The proposed surface water management scheme has been amended to reflect the proposed amendments to application 22/02255/REM, which were supplied to the Council earlier this week.

In terms of the recent consultation response from the LLFA, summarised below, I would make appropriate responses marked in green below. Please can you ensure that a full copy of this e-mail is appended to the reconsultation with the LLFA.

**DETAILS**  
PHASE 10  
ENGINEERING LAYOUT SHEET 1 OF 3

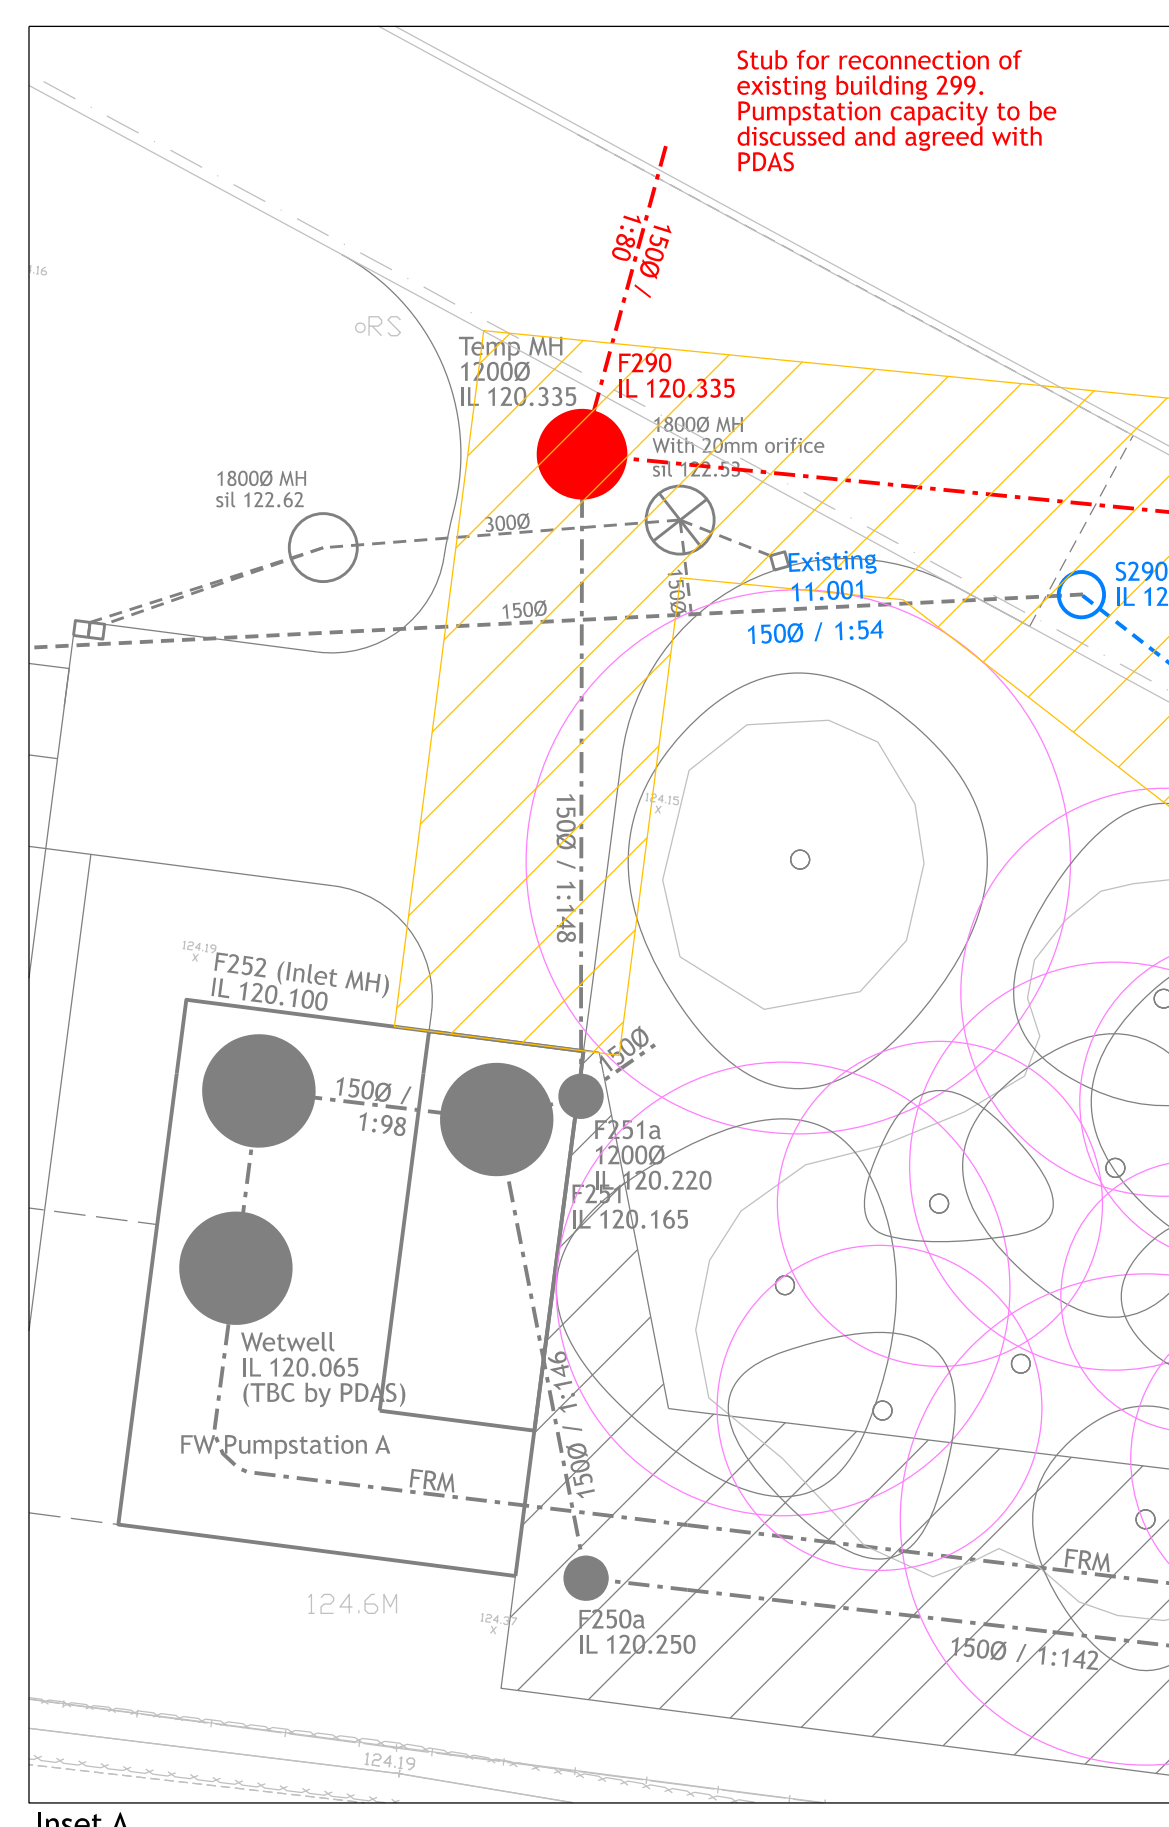
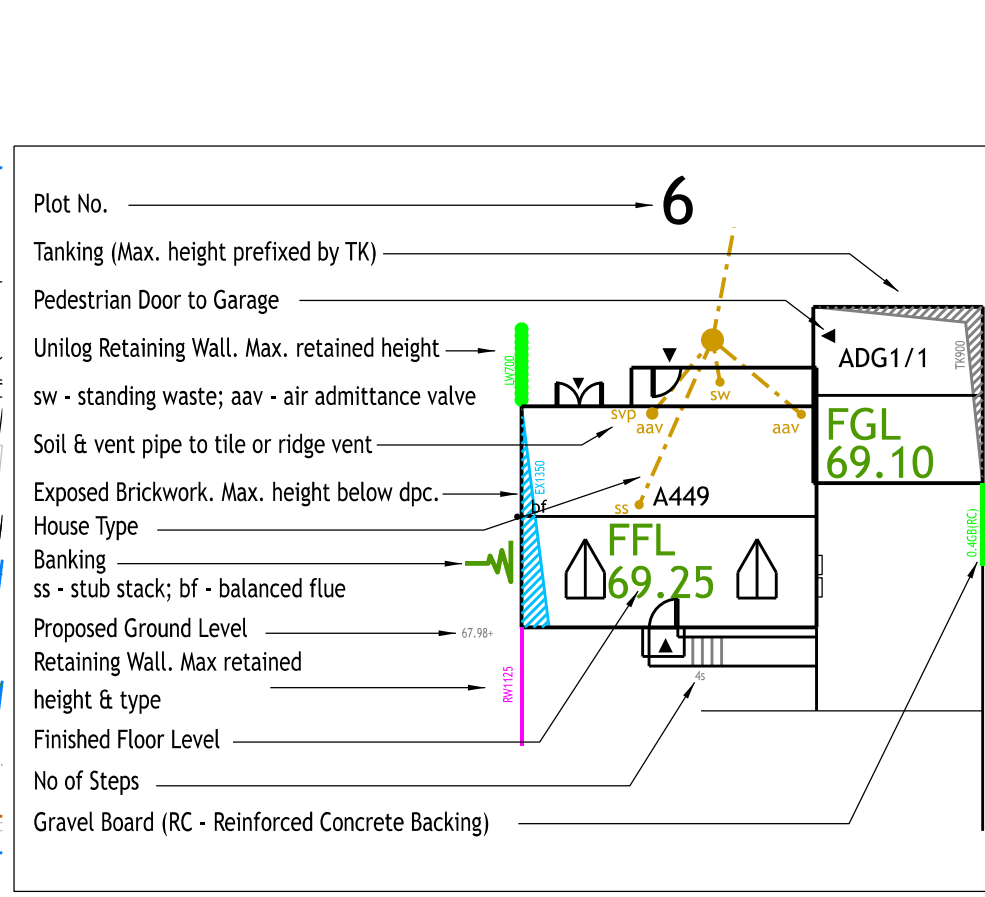
a) The SuDS hierarchy for discharging surface water drainage should be followed and demonstrated thoroughly- Permeable paving not considered as a form of treatment for the parking areas. Phase 10 boundary not included on the drainage drawing. Private areas proposed drainage needs to be shown.

g) Detailed drainage plan showing the location of the proposed SuDS features, catchment areas for each SuDS feature, pipework with direction of the flow, pipe sizes, manholes and other drainage accessories (including the specification and size) and the red line boundary- Provide surface water catchment plan clearly showing the extent of the impermeable areas and stating the area. Also state the area with 10% urban creep. Provide phase boundary. Cover levels are not shown for the drainage infrastructure.

Due to the EA's requirement for no infiltration on the phase opposite (phase 9), infiltration has also been designed out across of this phase too. As permeable paving will not be permitted to infiltrate, trapped gullies provide the necessary first stage treatment before all water passes through the petrol interceptors.

A Phase 10 impermeable areas plan is now included noting the response to point c) above. Phase boundary included, although for the full extents, the planning architectural layout should be referred to. Cover levels are provided within the FRAC calculations but have now been added to the plan too; These remain subject to detailed design.
